**From:** Patel, Uday [Uday.Patel@lancashire.gov.uk]  
**Sent:** 04 March 2013 15:28  
**To:** Claire Booth  
**Cc:** planning  
**Subject:** 3/2013/0089 - Two-storey extension to the side of the dwelling and a new sunroom. Re-submission - 16 Hawthorne Place Clitheroe Lancashire BB7 2HU

Planning Application Reference: 3/2013/0089

Proposal: Two-storey extension to the side of the dwelling and a new sunroom. Re-submission.

Location: 16 Hawthorne Place Clitheroe Lancashire BB7 2HU

Fig N°
347/3/2
A

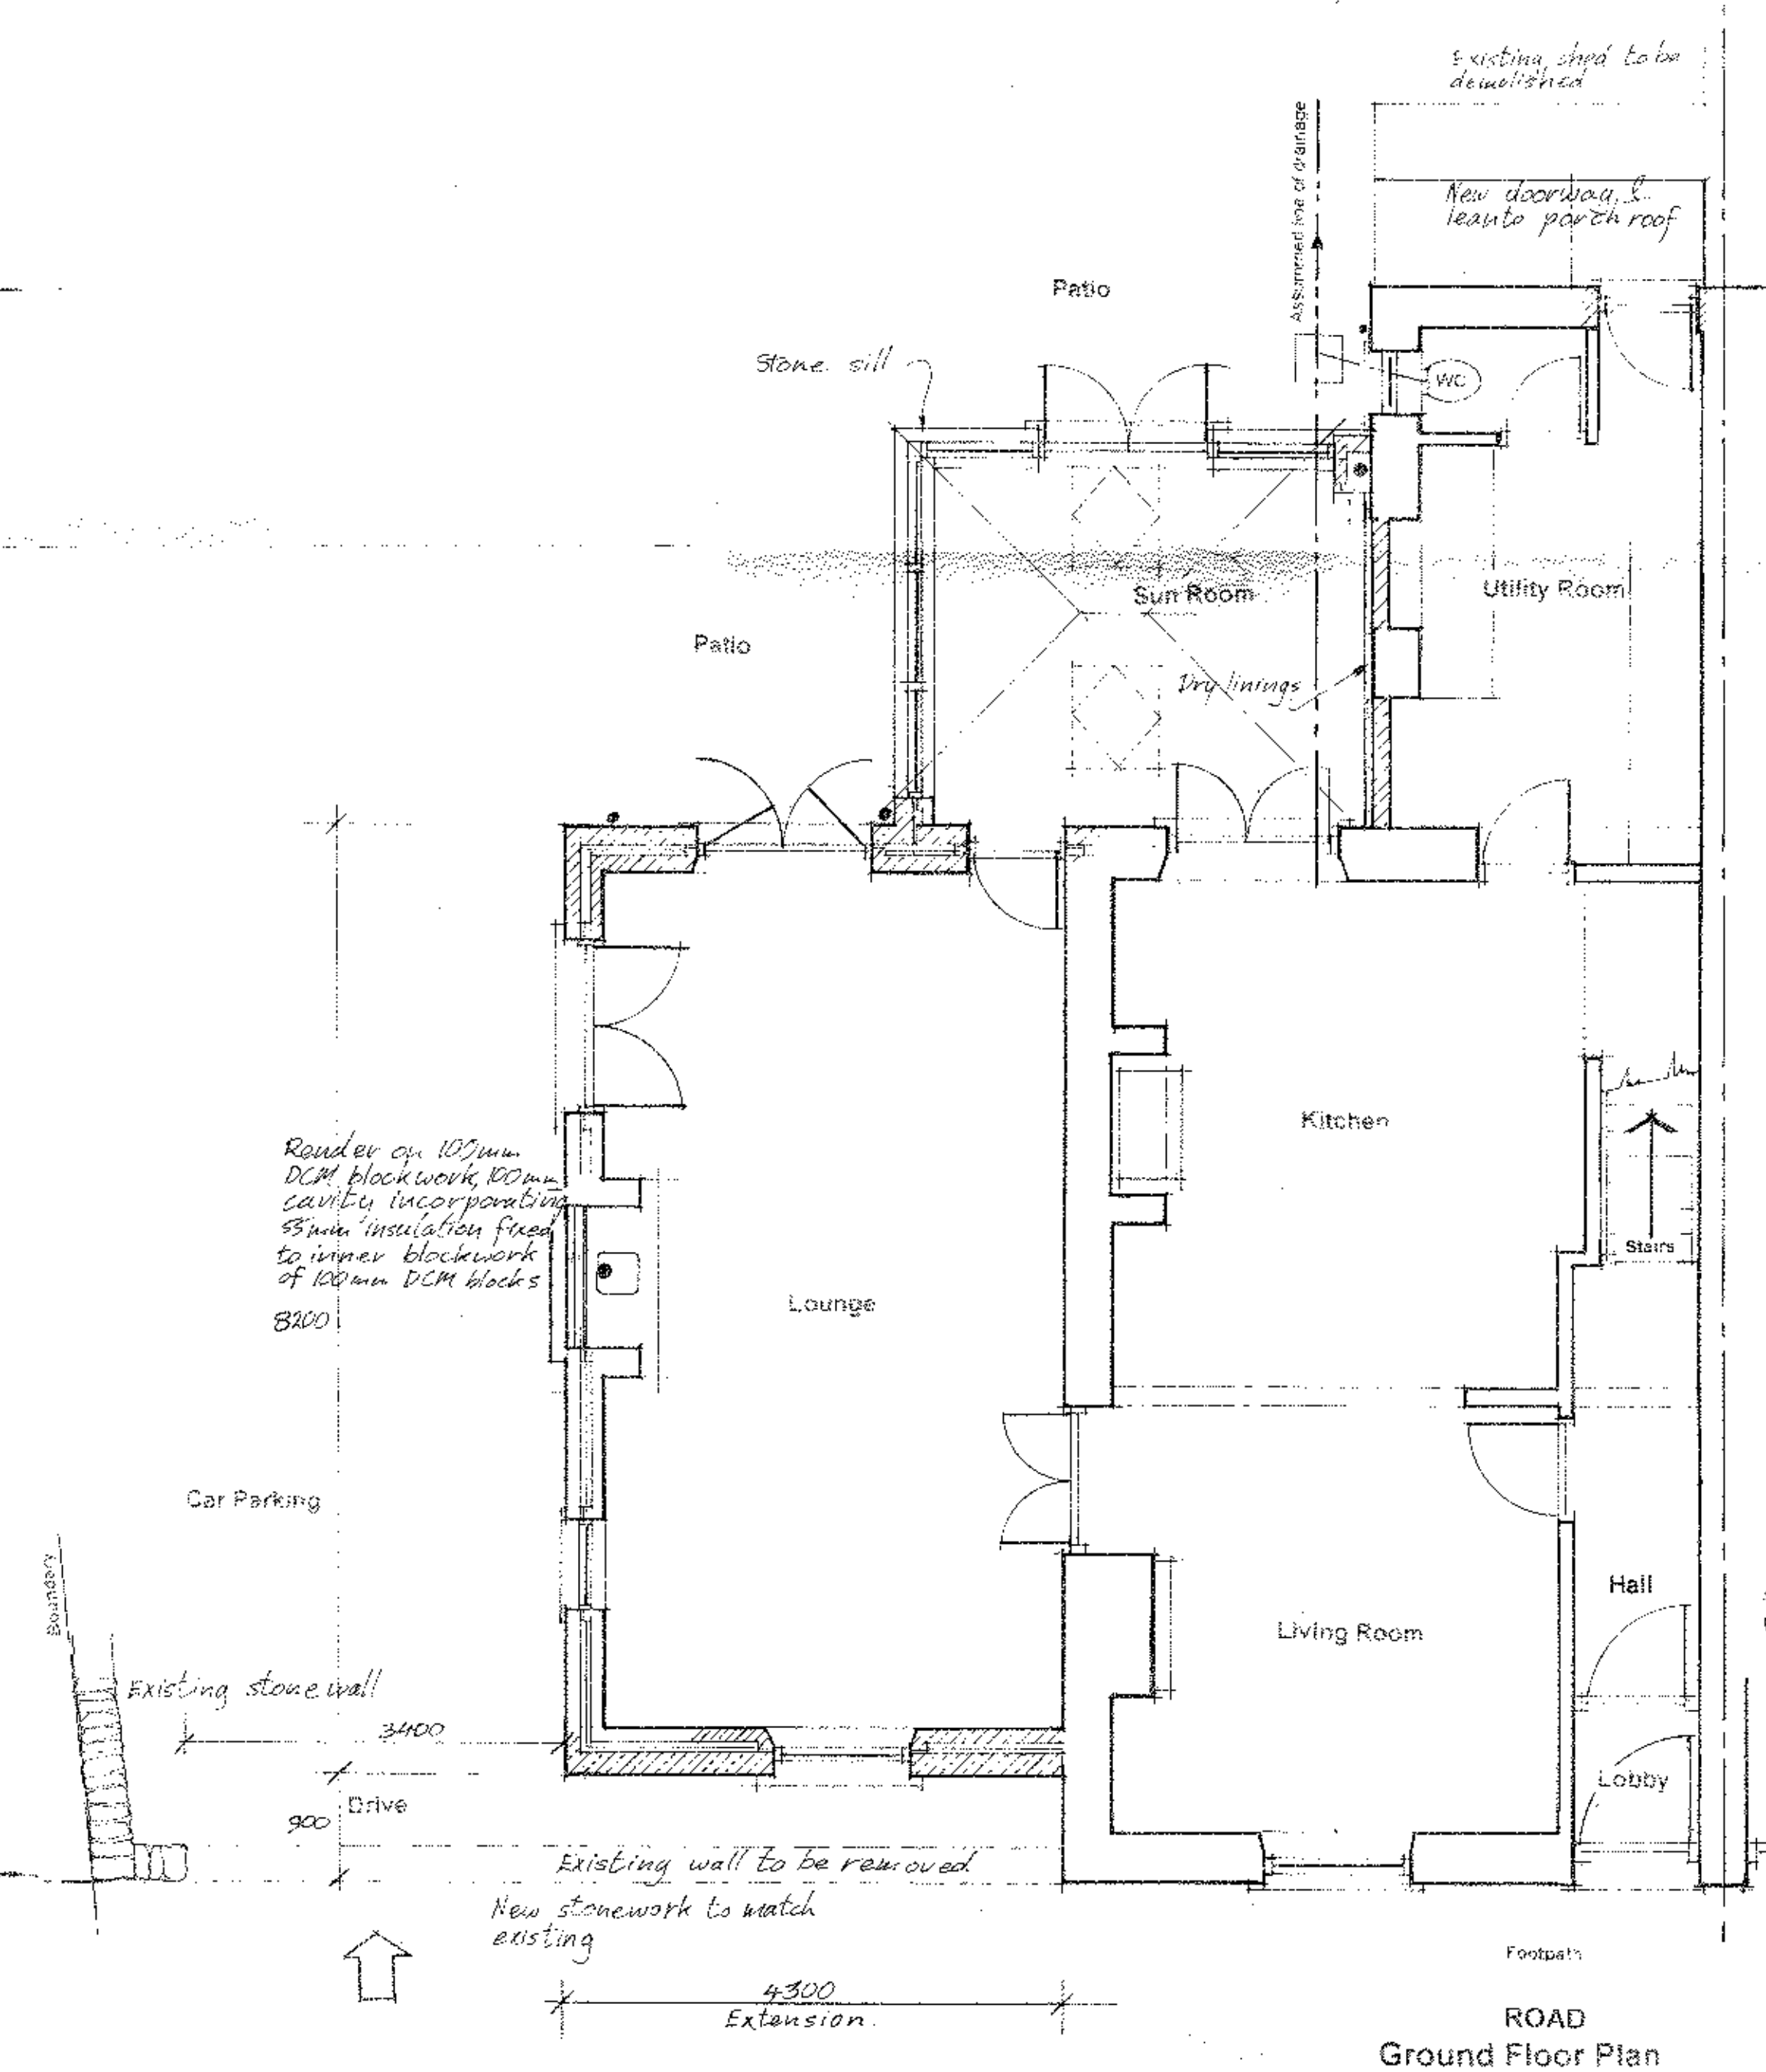
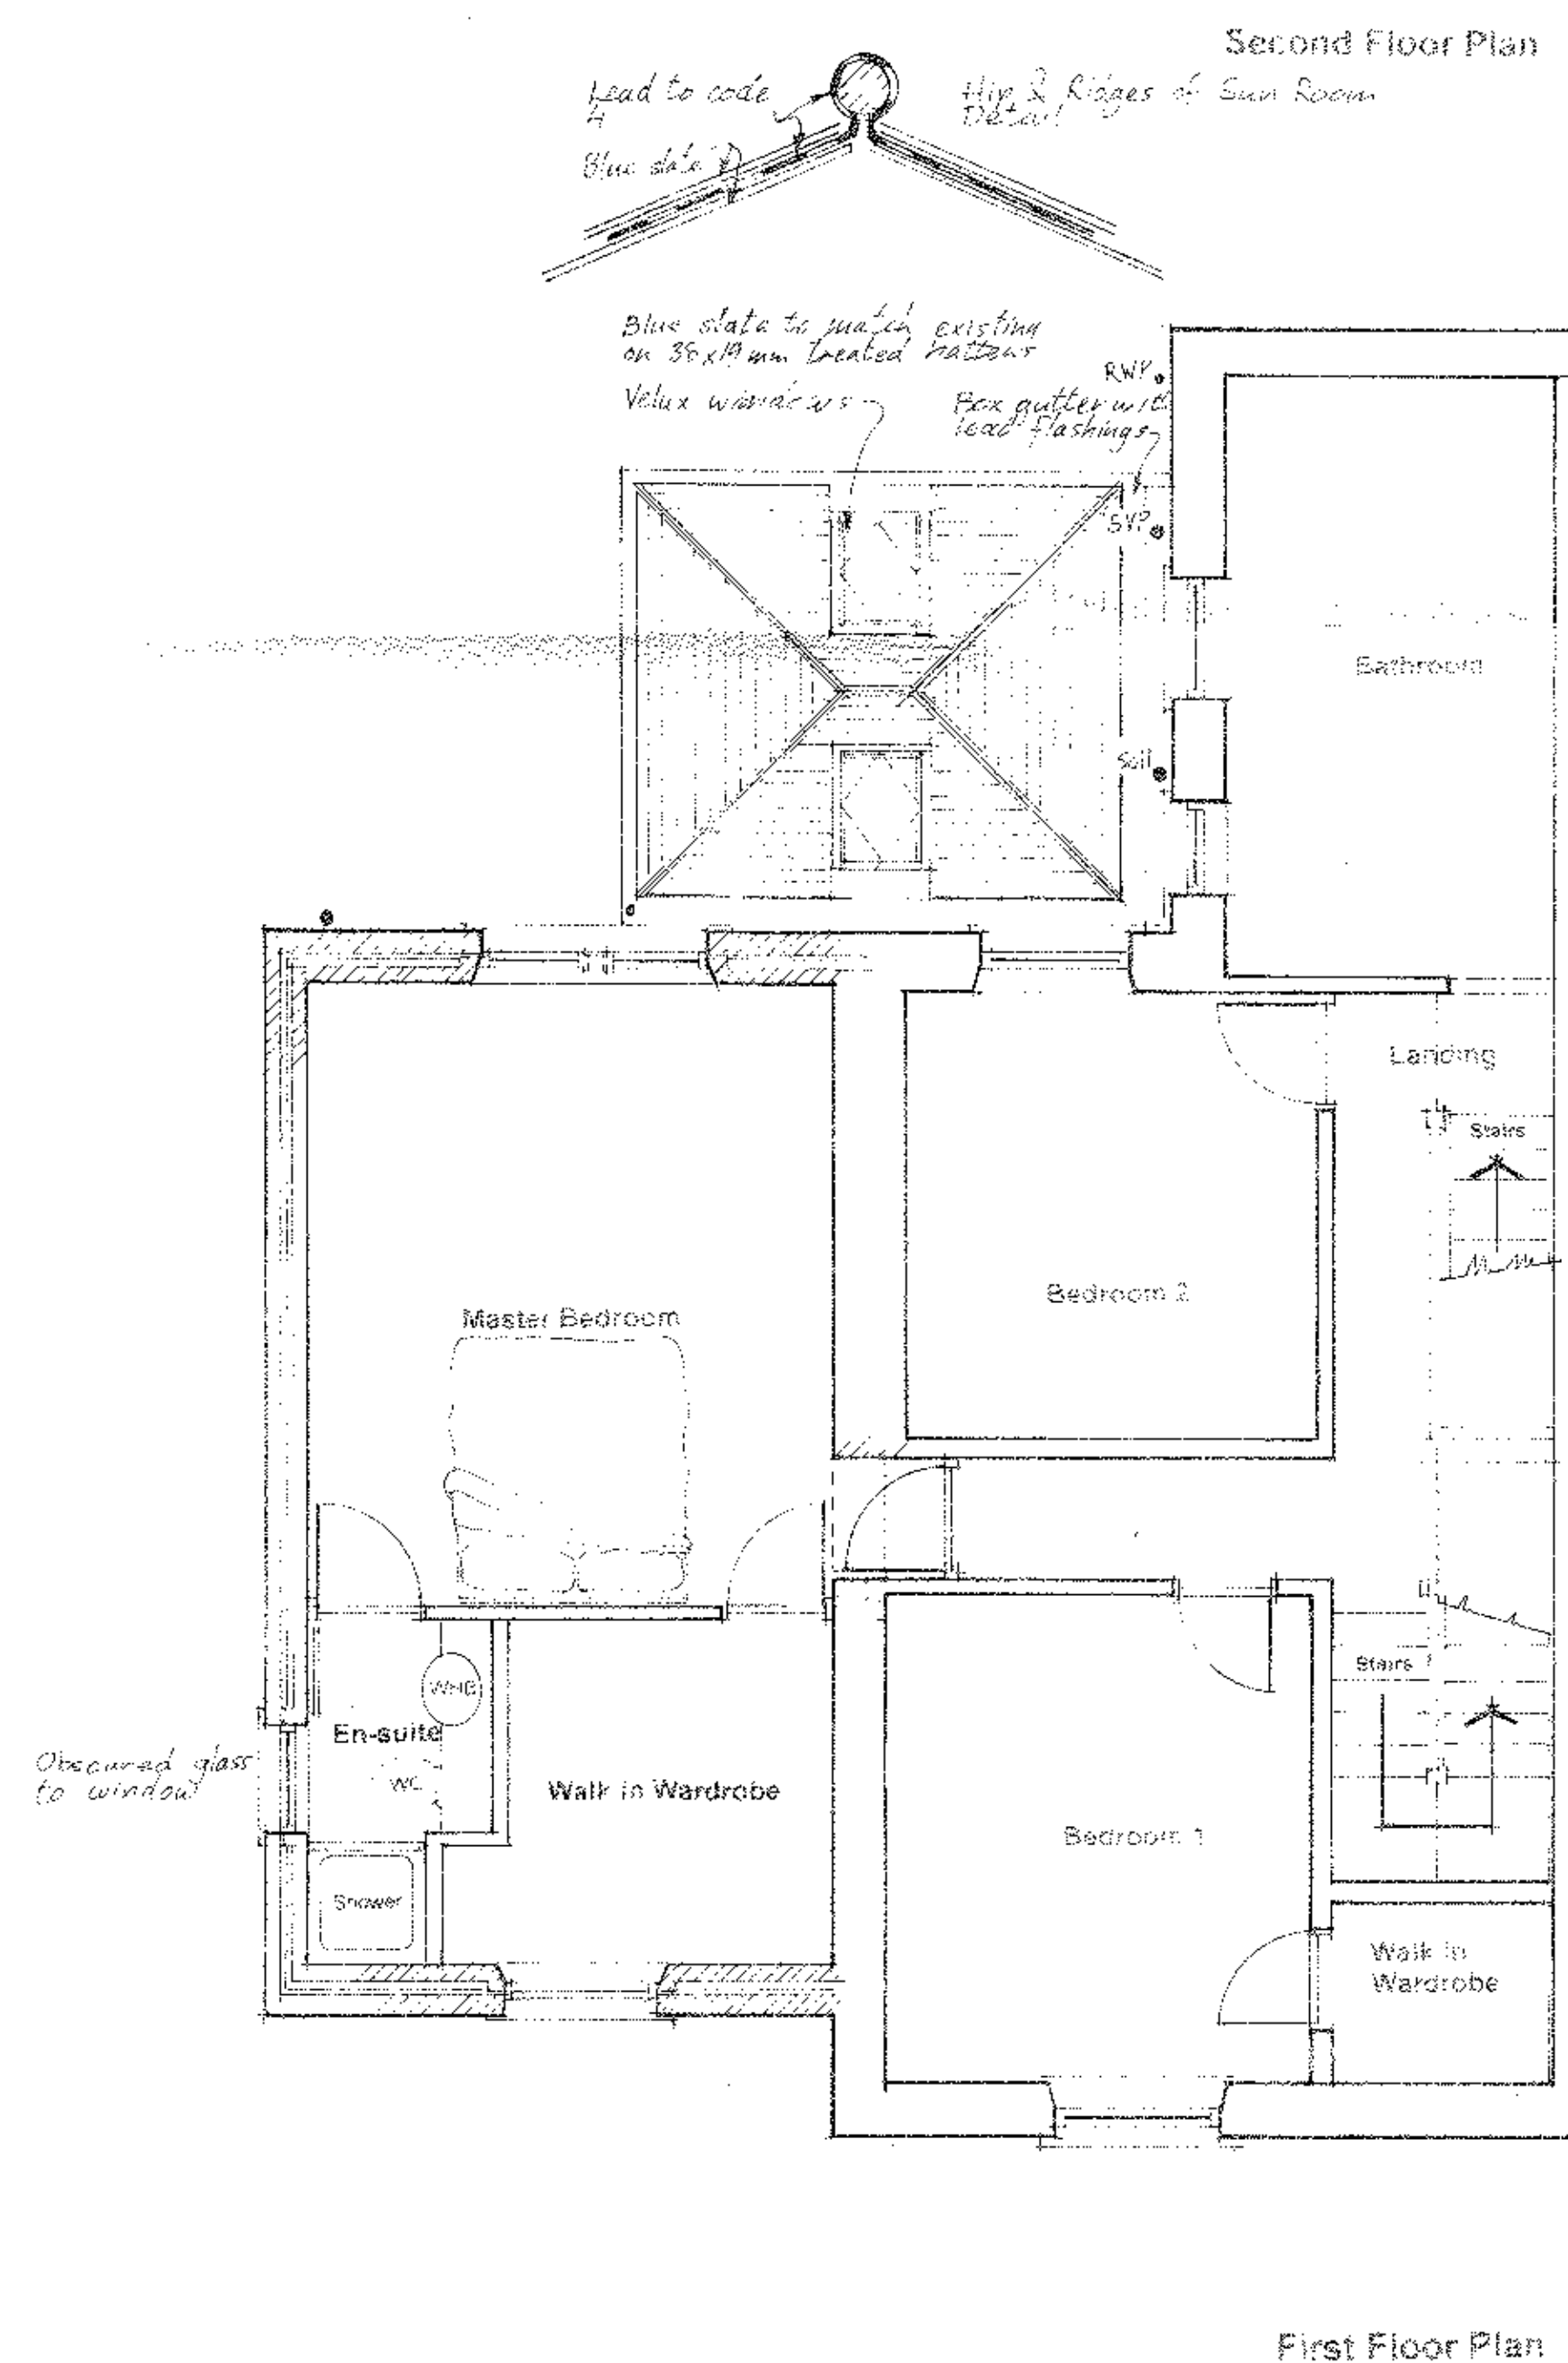
It is realised that the proposed drive way is able to accommodate two vehicles in tandem parking. There will be off site works involved in terms of provision of dropped crossing, restoration of the footway surface etc. These works will be carried out by the LCC highway authorities. The cost of such works will be borne by the applicant.

The level of the driveway at proposed access shall be constructed 0.150m above the crown level of the carriageway of Hawthorne road. Reason: To safeguard the future reconstruction of the highway.

The vehicular access shall remain un-gated. Reason: For no stoppage of vehicles to access the property causing other vehicles behind to stop.

The drive way/access shall be appropriately paved. Reason : For not to cause the loose material come on the road causing hazardous conditions.
